Re: Planning Application for the Revision/Variation of Condition 2 of permission 20/02859/F:

Approved Proposal: Erection of a general purpose agricultural building

Location: College Farm, Main Street, Wendlebury, OX25 2PR

ELEVATIONS, As Proposed and As Existing
 1:200 TPH October 2020
 Original at A1 Drwg no. 20 / 182.02 Rev A

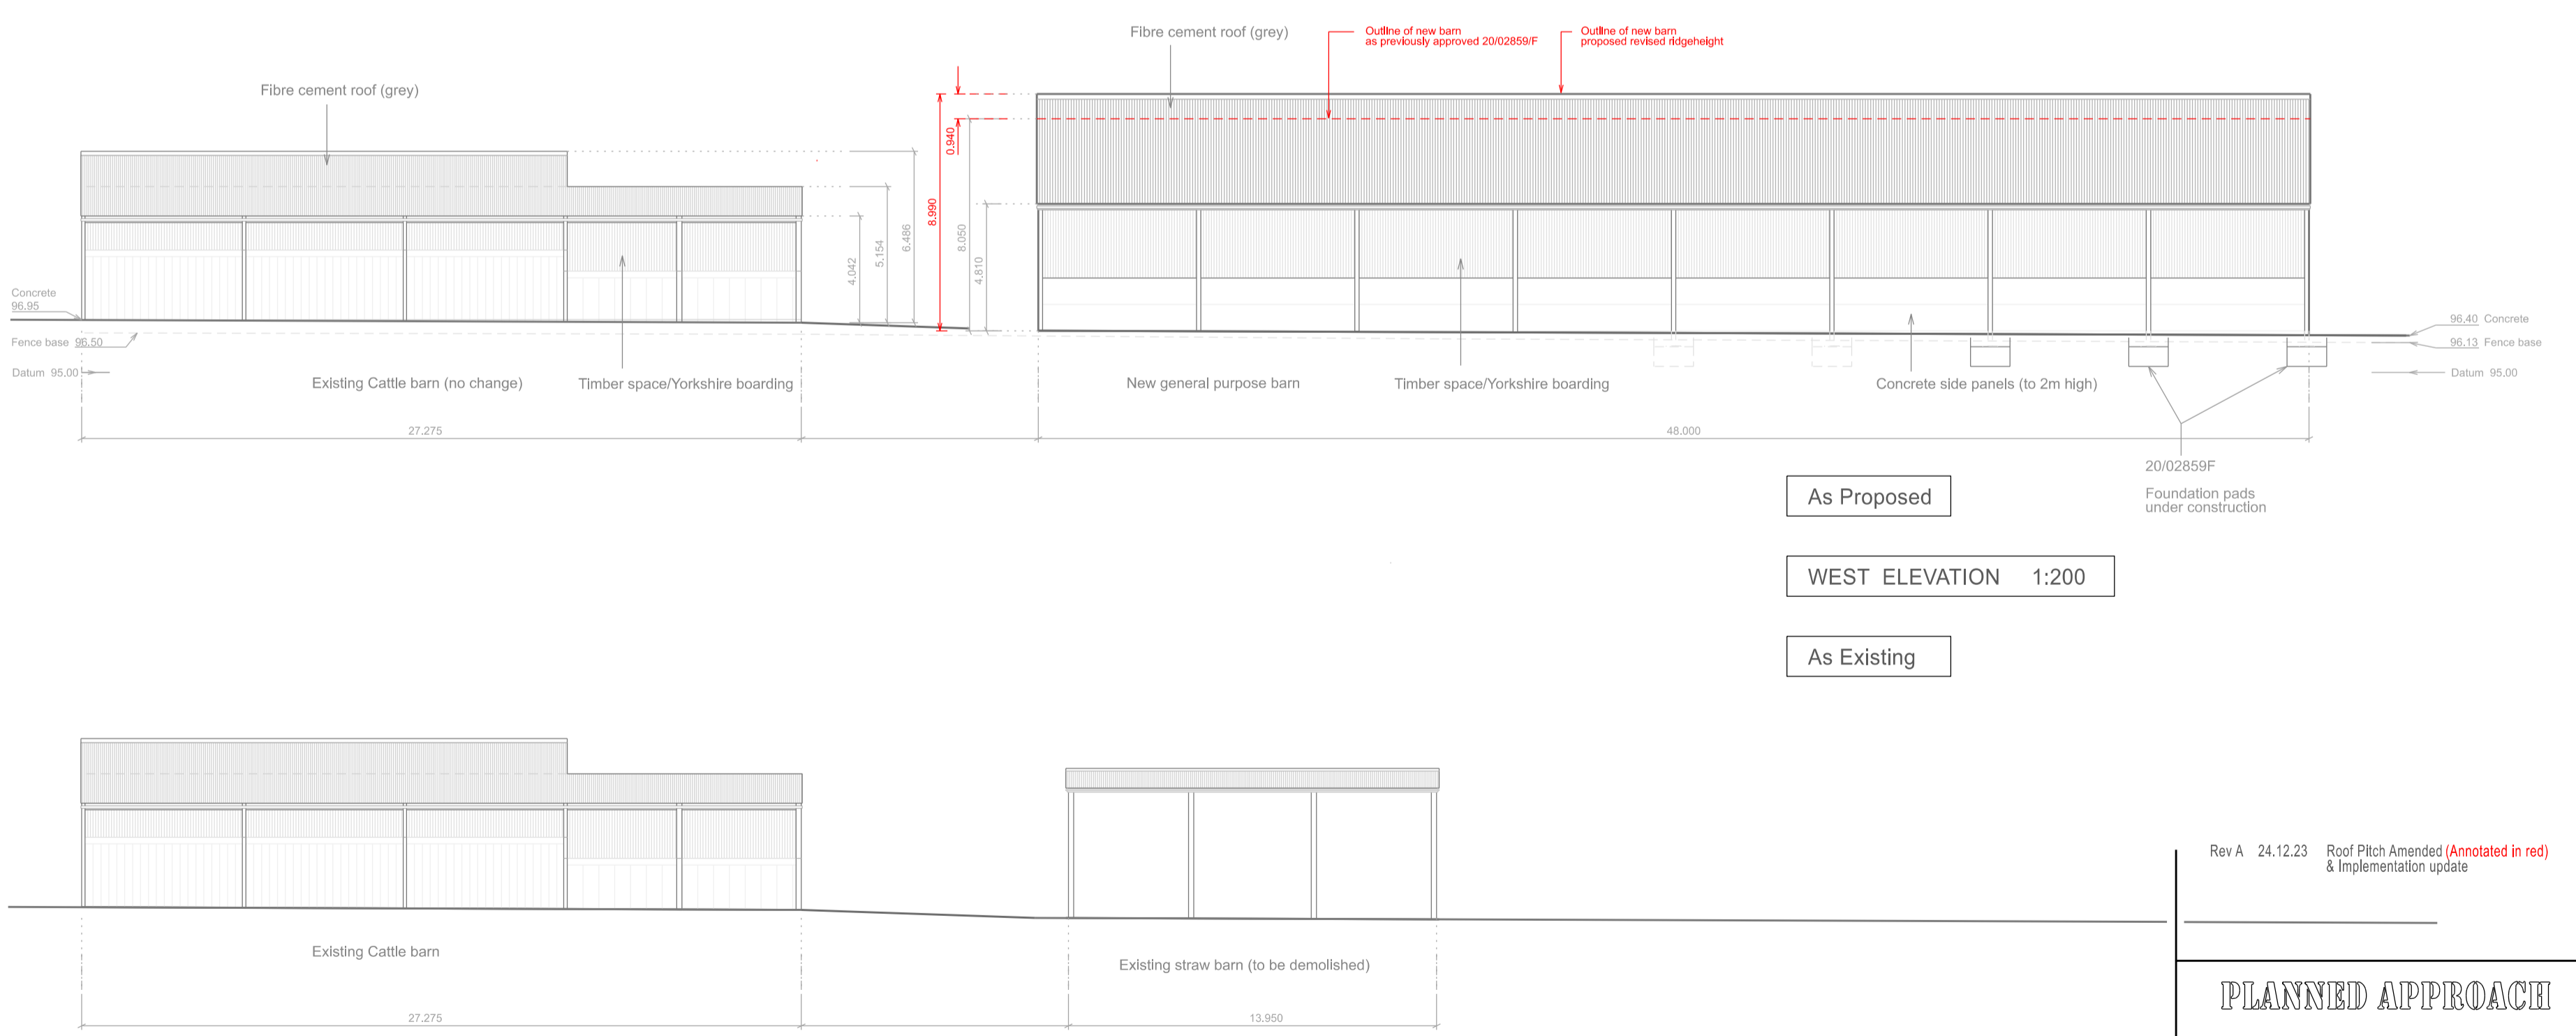
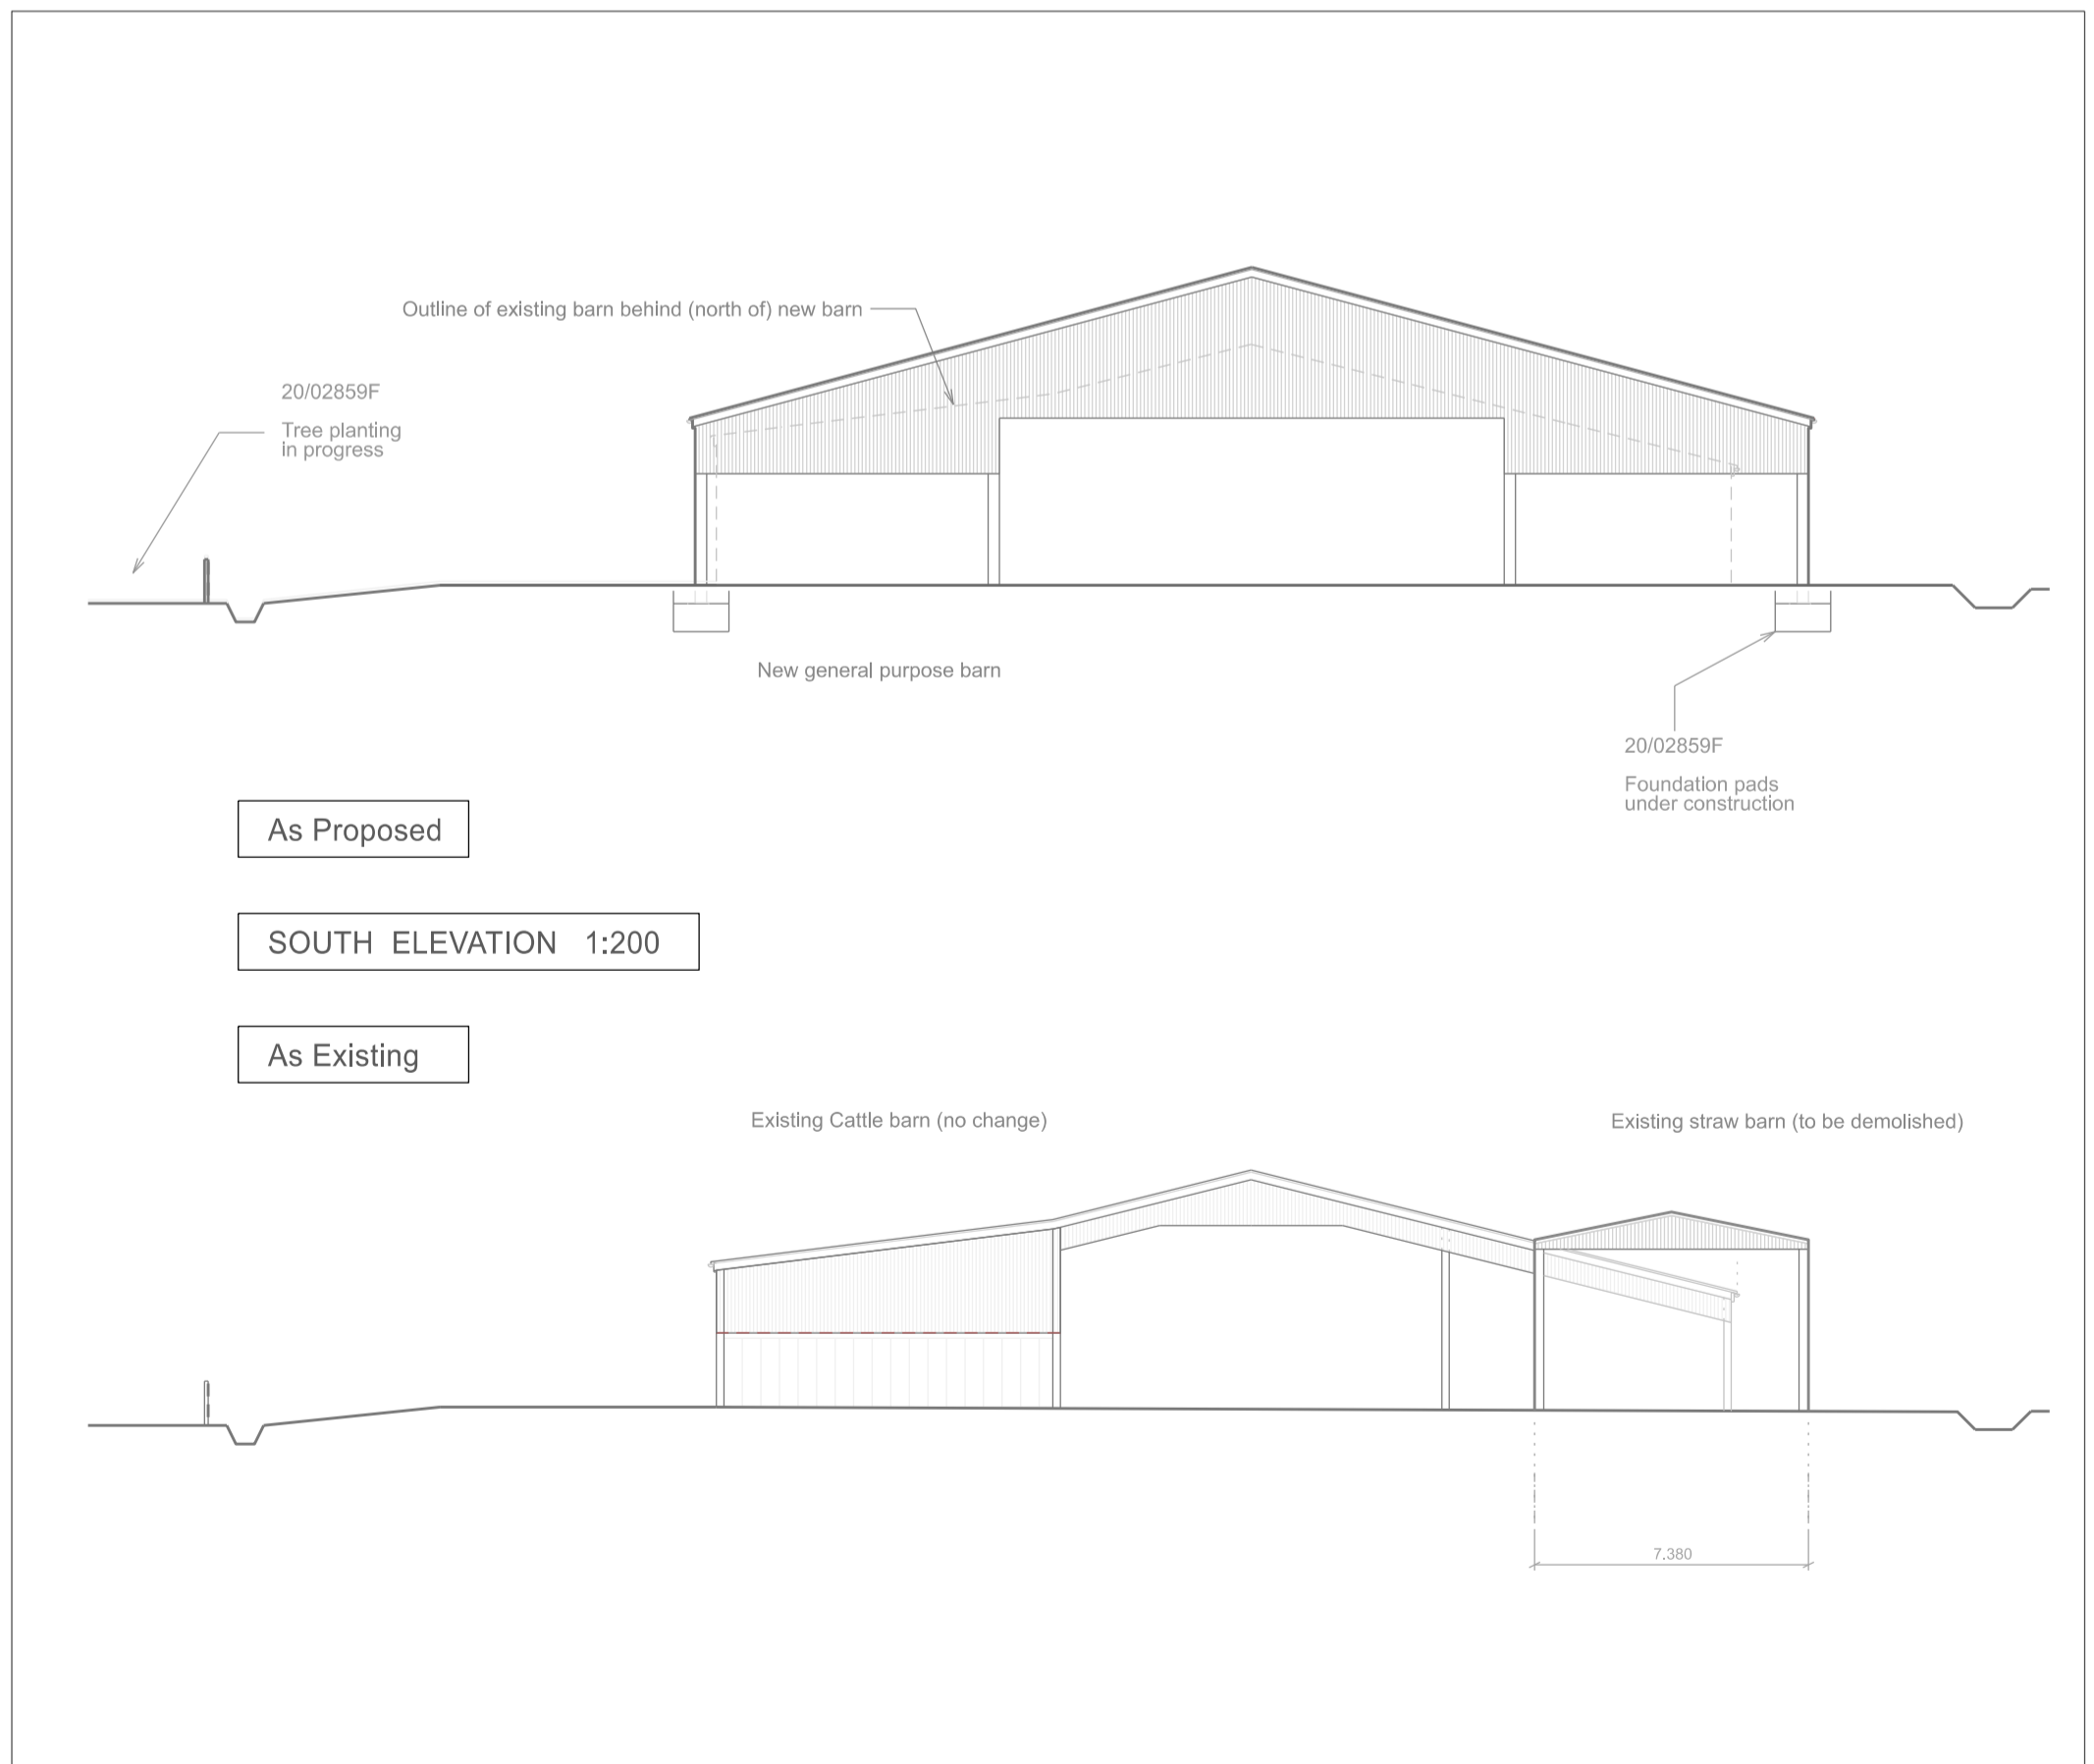
Please find the attached documentation for the Planning Application for the variation of Condition No.2 of planning permission 20/02859/F. We wish to change the roof pitch from 12 to 15degrees, all other aspects of the proposal remain as approved. The quotes received from the steel frame manufactures indicate that a 15degree pitch is a more efficient use of steel, and funds, than a 12 degree pitch. This change will result is a change of ridge height from 8.05m to 8.99m. With agricultural contractors' machinery becoming increasingly tall, this revision will also facilitate easier tipping of trailers carrying feed and silage inside the building.
